Per Jeff Rice's EDARP comment on 9/14 when he requested the GEC Plan be separated from the Site Development Plan file:  
 - Include a title sheet (can be copied from the SDP and modified) and signature blocks (be sure to match GEC Checklist items "ff", "hh", and "jj")  
 - also include the 29 EPC GEC Notes on sheet C1.2

**INITIAL EROSION CONTROL PLAN**  
 SUPER STAR CAR WASH - FALCON MARKETPLACE LOT 10  
 SITE DEVELOPMENT PLAN  
 COLORADO  
 EL PASO COUNTY

DESIGN SWK	DRAWN SWK	CHKD TOP
SCALE H: 1" = 20' V: 1" = XXX'		
JOB No. 020441-01-001		
DATE : 02/09/2021		
SHEET C2.0

NOT FOR CONSTRUCTION		
DESIGN SWK	DRAWN SWK	CHKD TOP
SCALE: H: 1" = 20' V: 1" = XXX'		
JOB No. 020441-01-001		
DATE: 02/09/2021		
SHEET C2.1

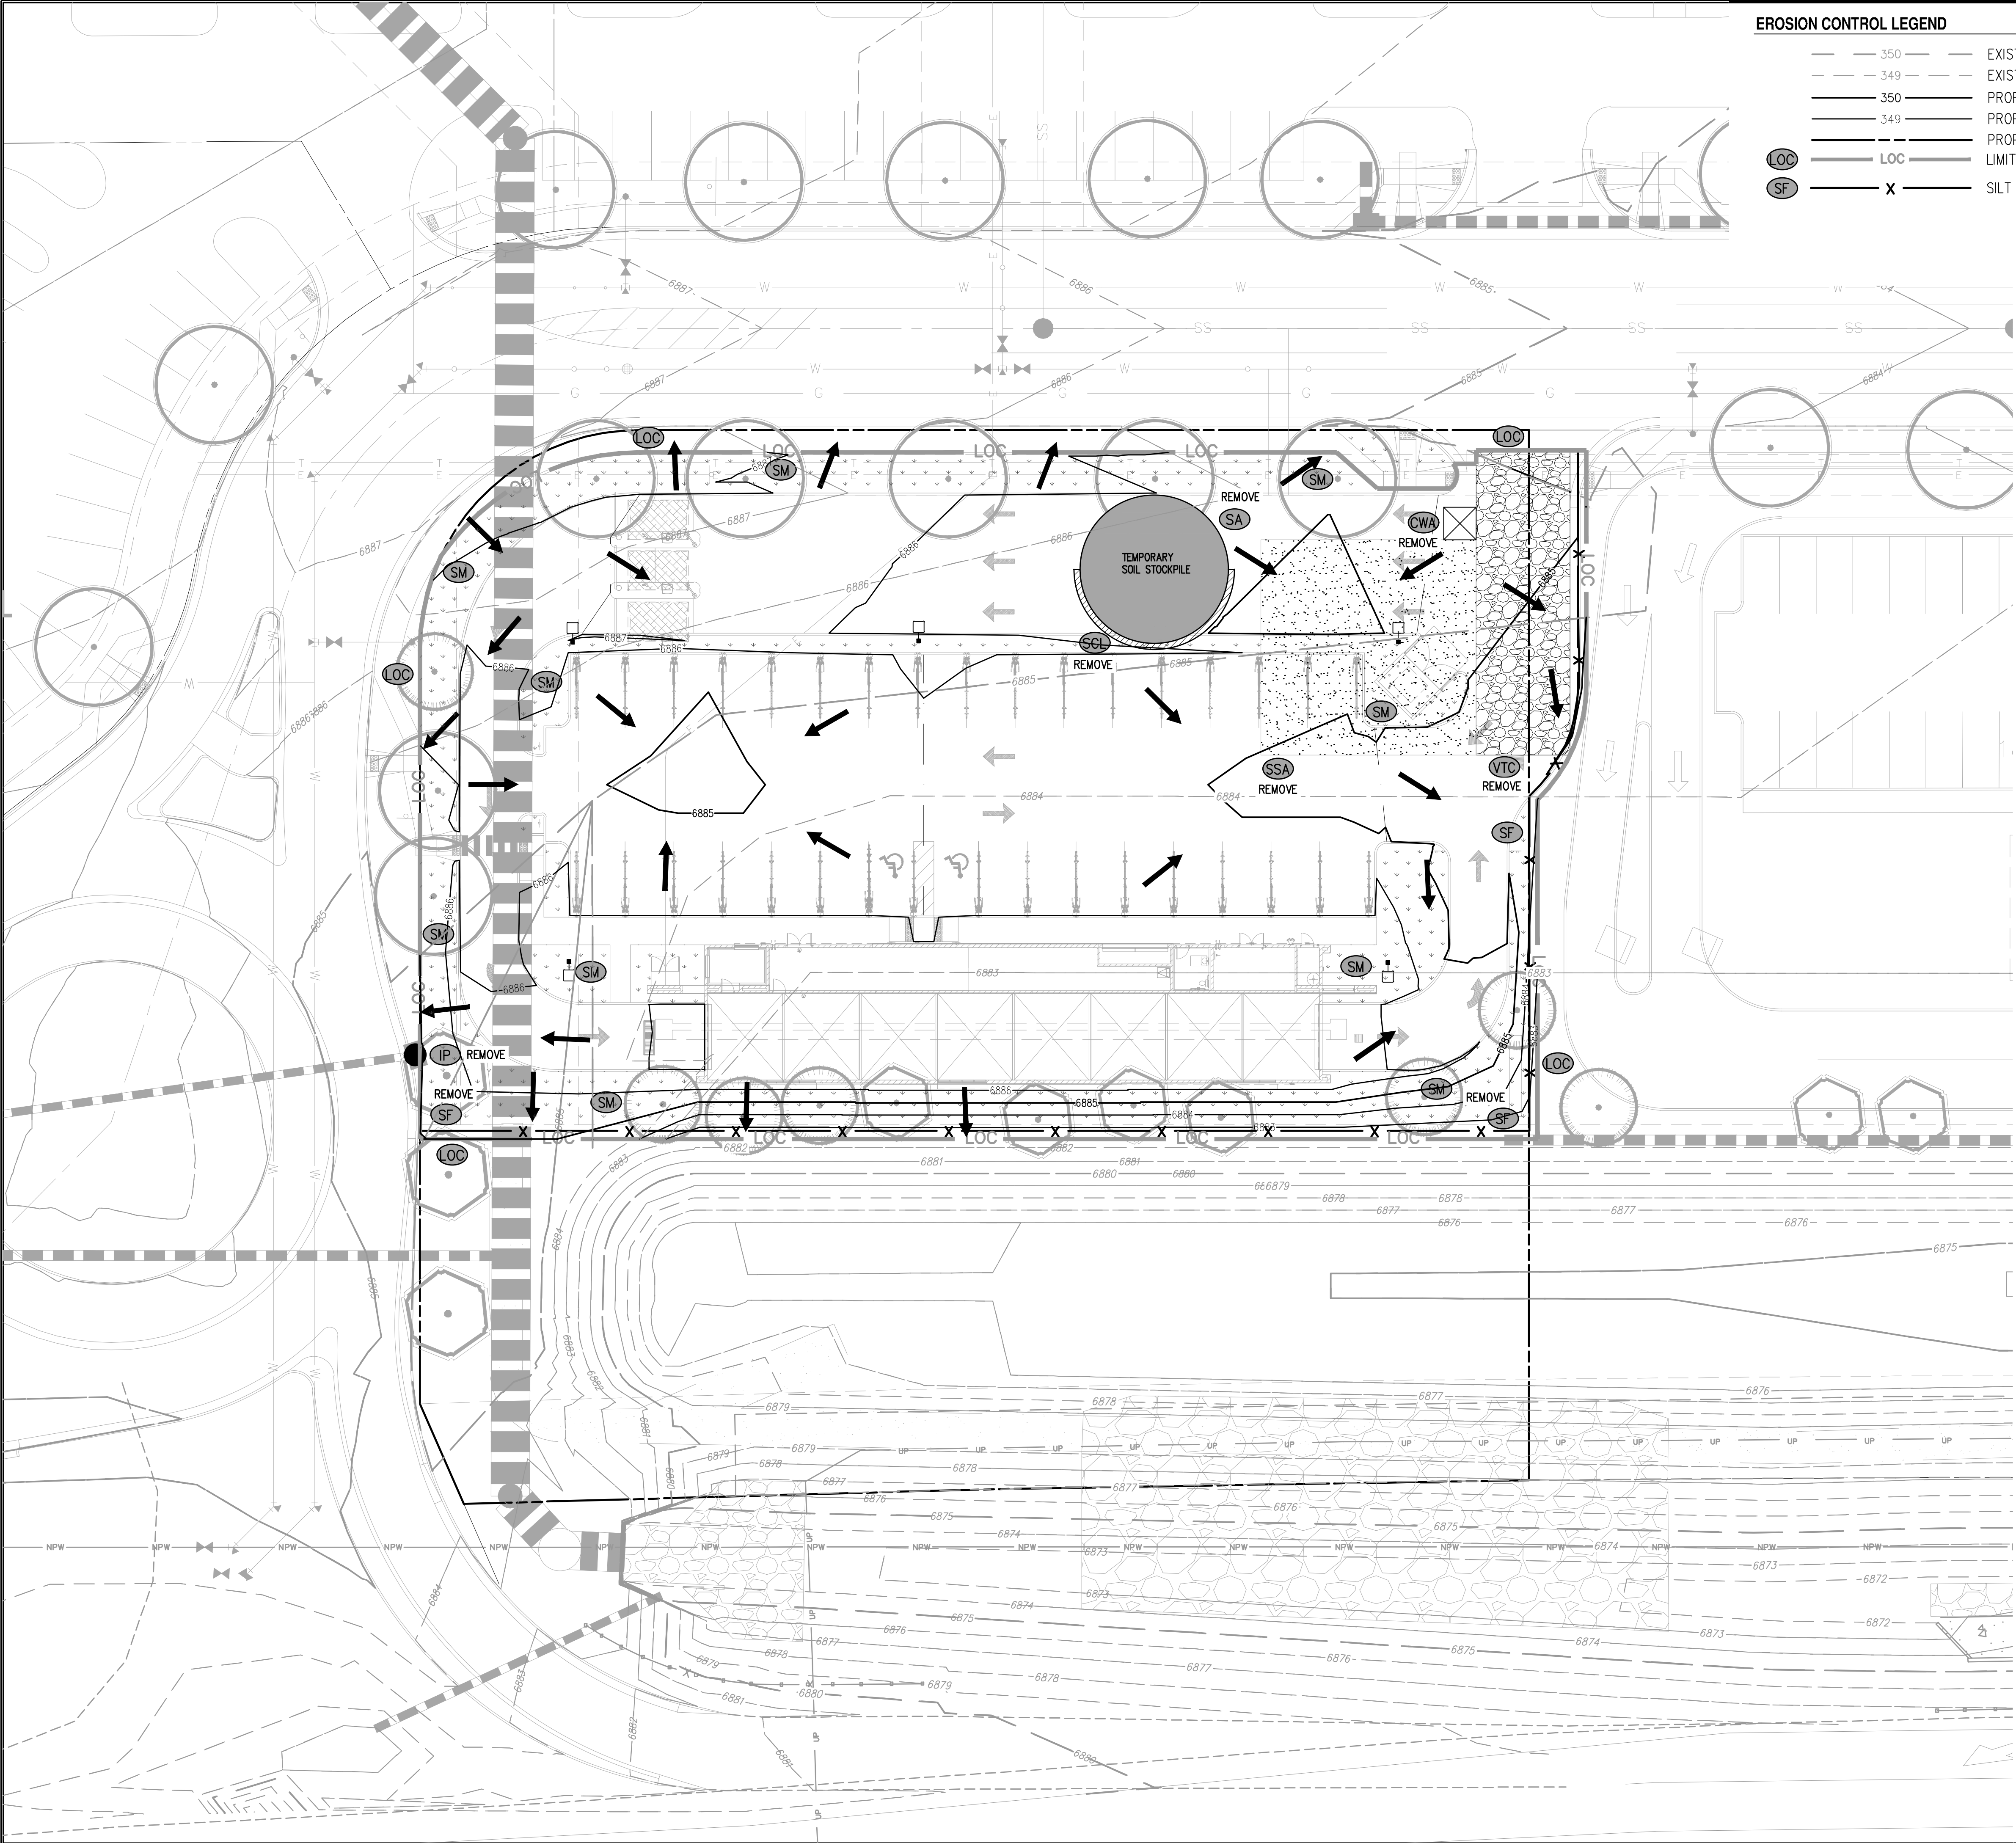
Items H and M. If "limits of disturbance" and "construction boundary" are the same, change to "limits of construction/disturbance" or otherwise show as separate line types for each on the legend and figure.

GEC Checklist Items H and M: If "limits of disturbance" and "construction boundary" are the same, change to "limits of construction/disturbance" or otherwise show as separate line types for each on the legend and figure (typical comment all plan shts)
